5 April 2022

DESIGN INTEGRITY PANEL BRIEFING AND COMMENTS

On Wednesday 23 March 2022 Gurner and its consultants briefed the Design Integrity Panel in relation to the design changes arising between the PTW winning mixed use BTS tower and the proposed mixed use BTR tower.

Title
B-GENERAL ARRANGEMENT PLANS
LEVEL 00 GROUND FLOOR PLAN

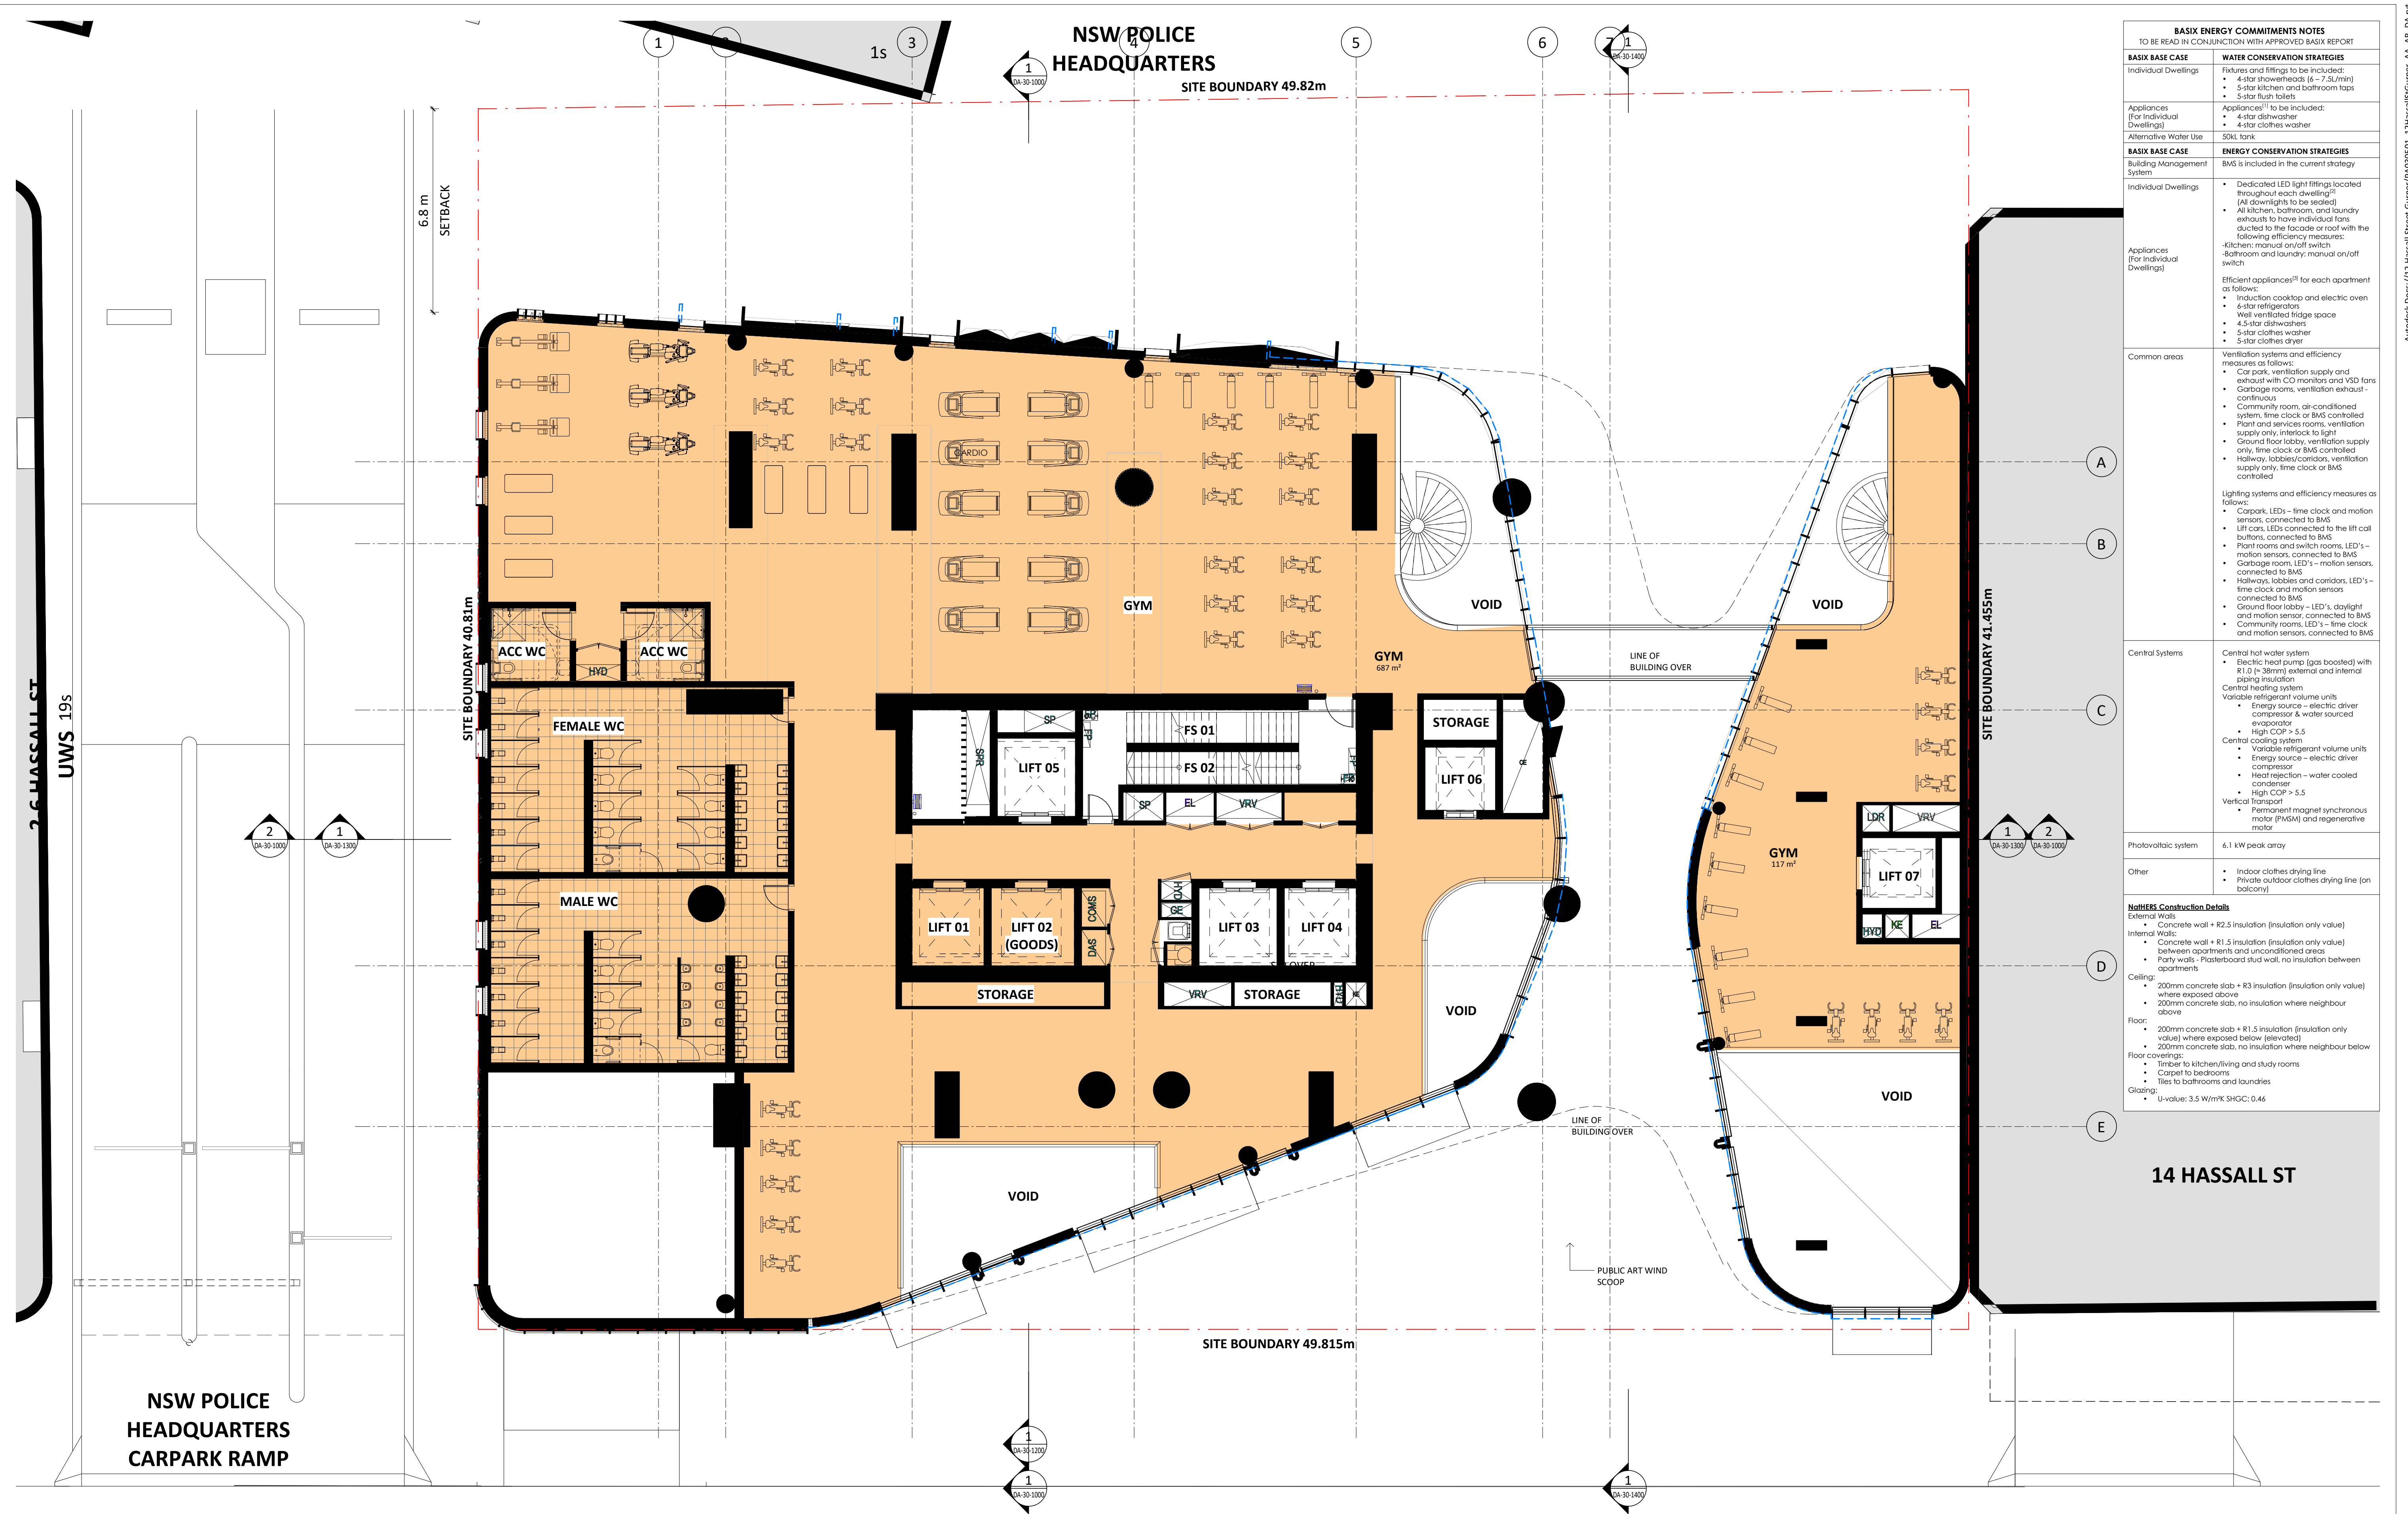
- Provide additional information that compares the changes to the design excellence scheme lobby spaces to the revised BTR scheme.
- Proposed substation – where was it within the design competition scheme and details of the new location?

Title
C-ELEVATIONS
NORTH ELEVATION 1-300

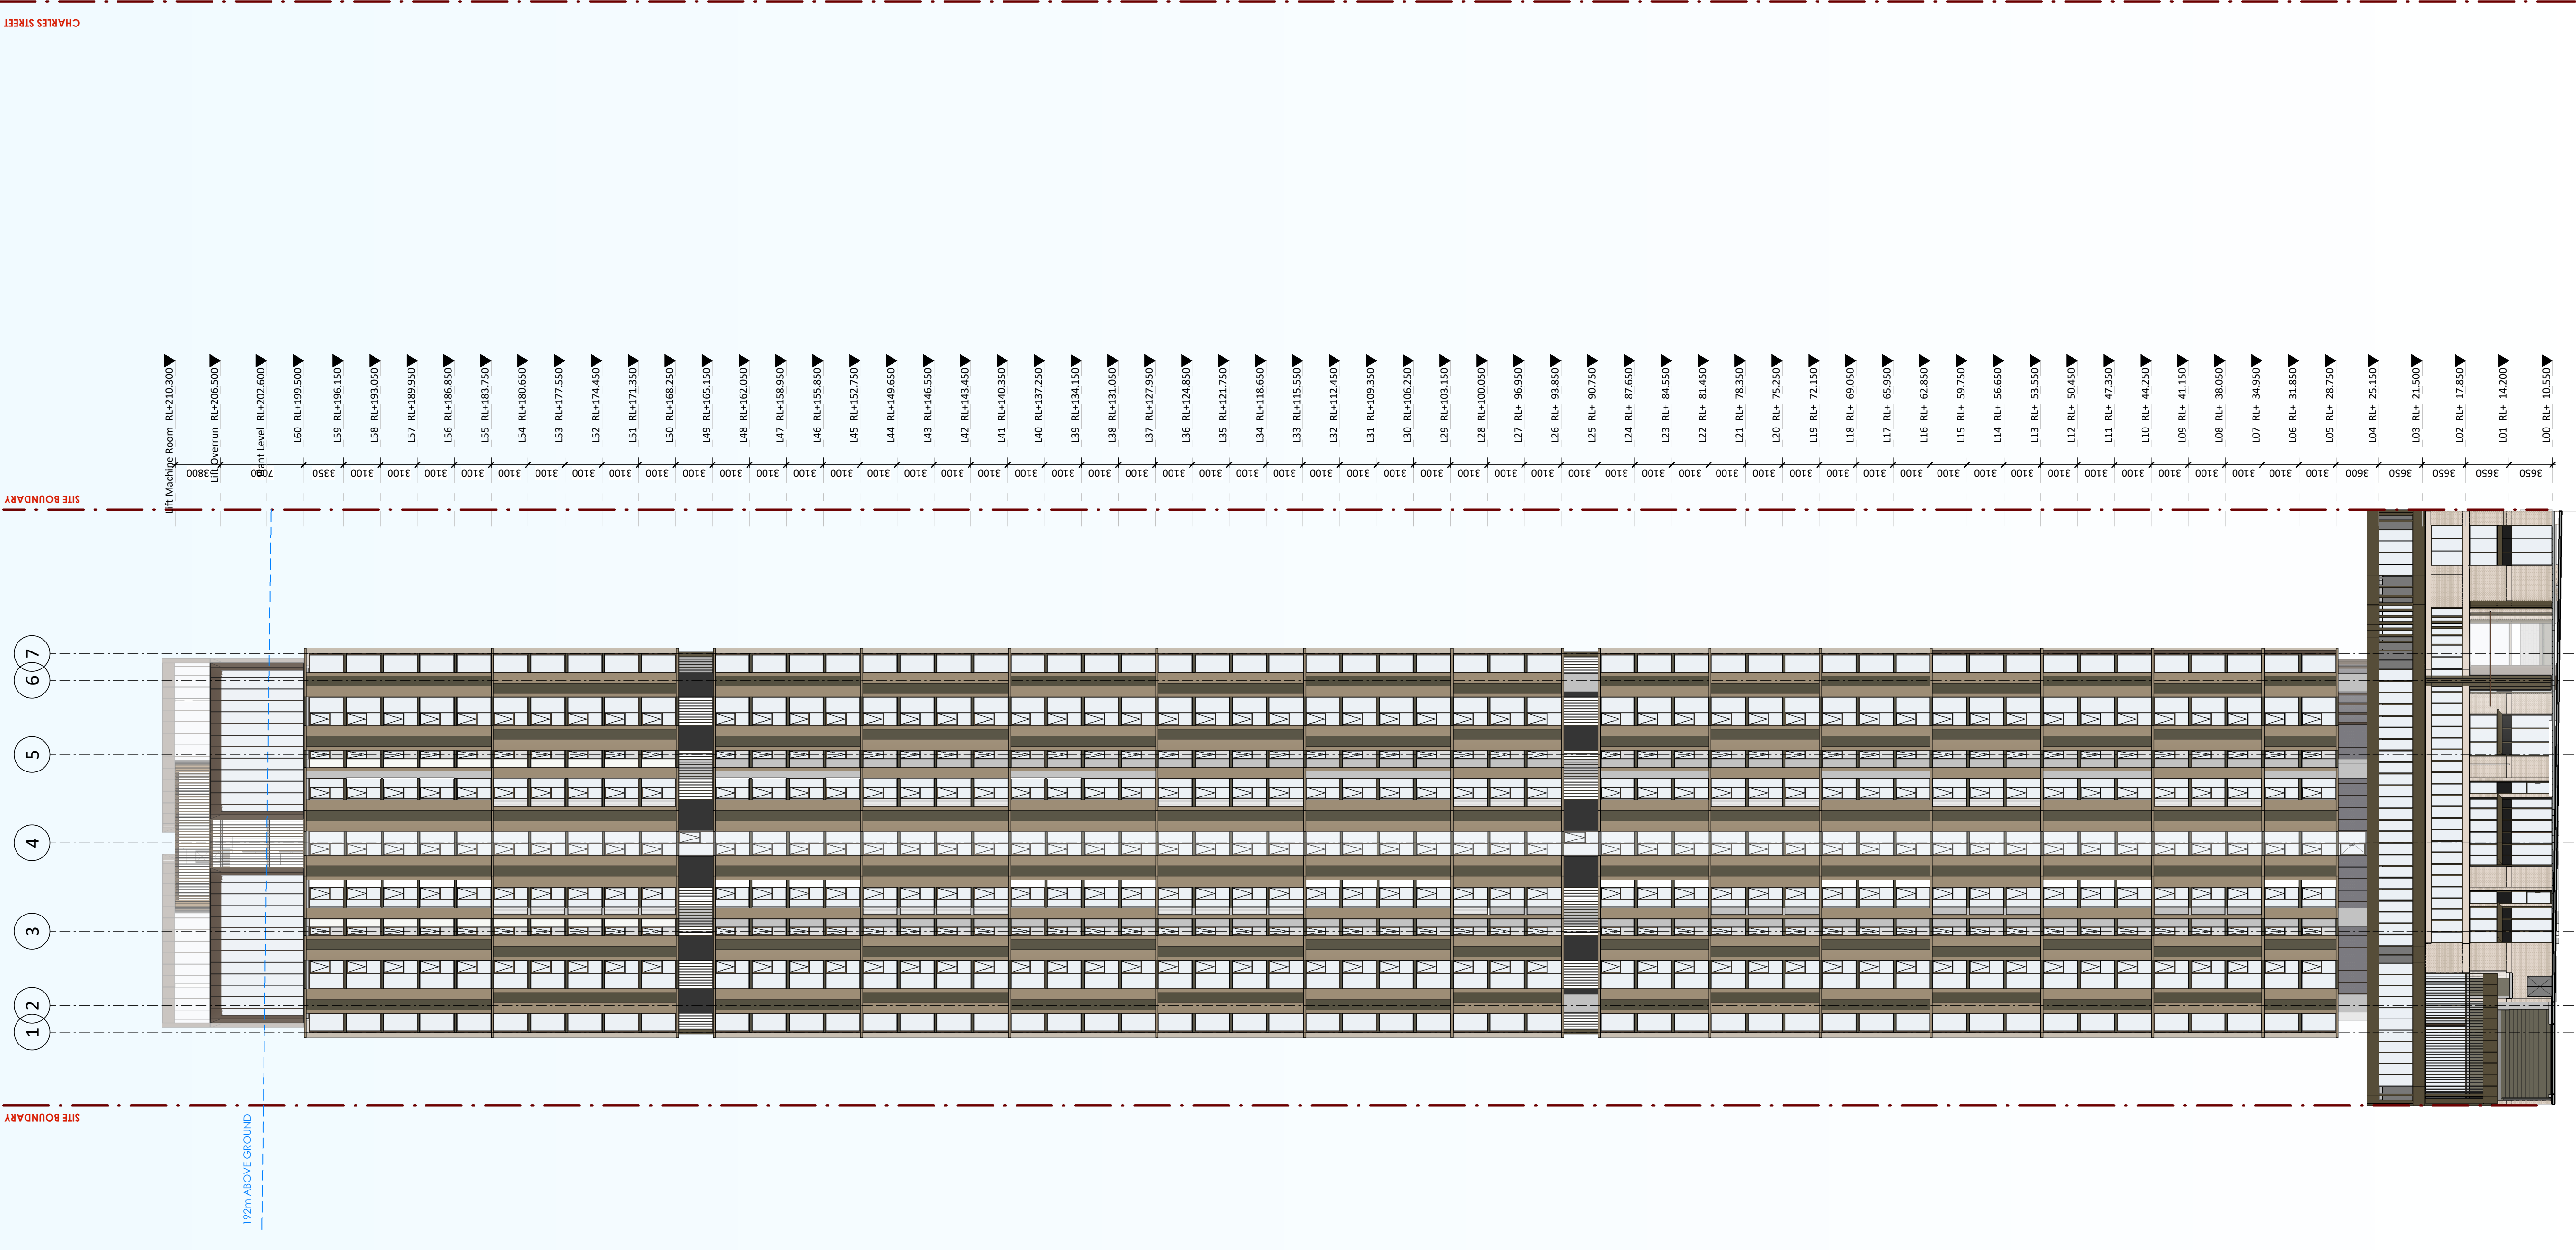
- Provide details of what the DCP setback is, what was accepted at the competition winning scheme, and what is proposed under the revised BTR scheme.
- Provide an interface diagram which explains the buildings to the north and if there are any resultant impacts coming from the reduced setback.
- Northern façade balconies – are there privacy issues resulting from the placement of balconies proposed in the revised BTR scheme?
- Provide details of the materiality of the balconies (previously were inset and now glazed) and how wind mitigation is being incorporated within the scheme.
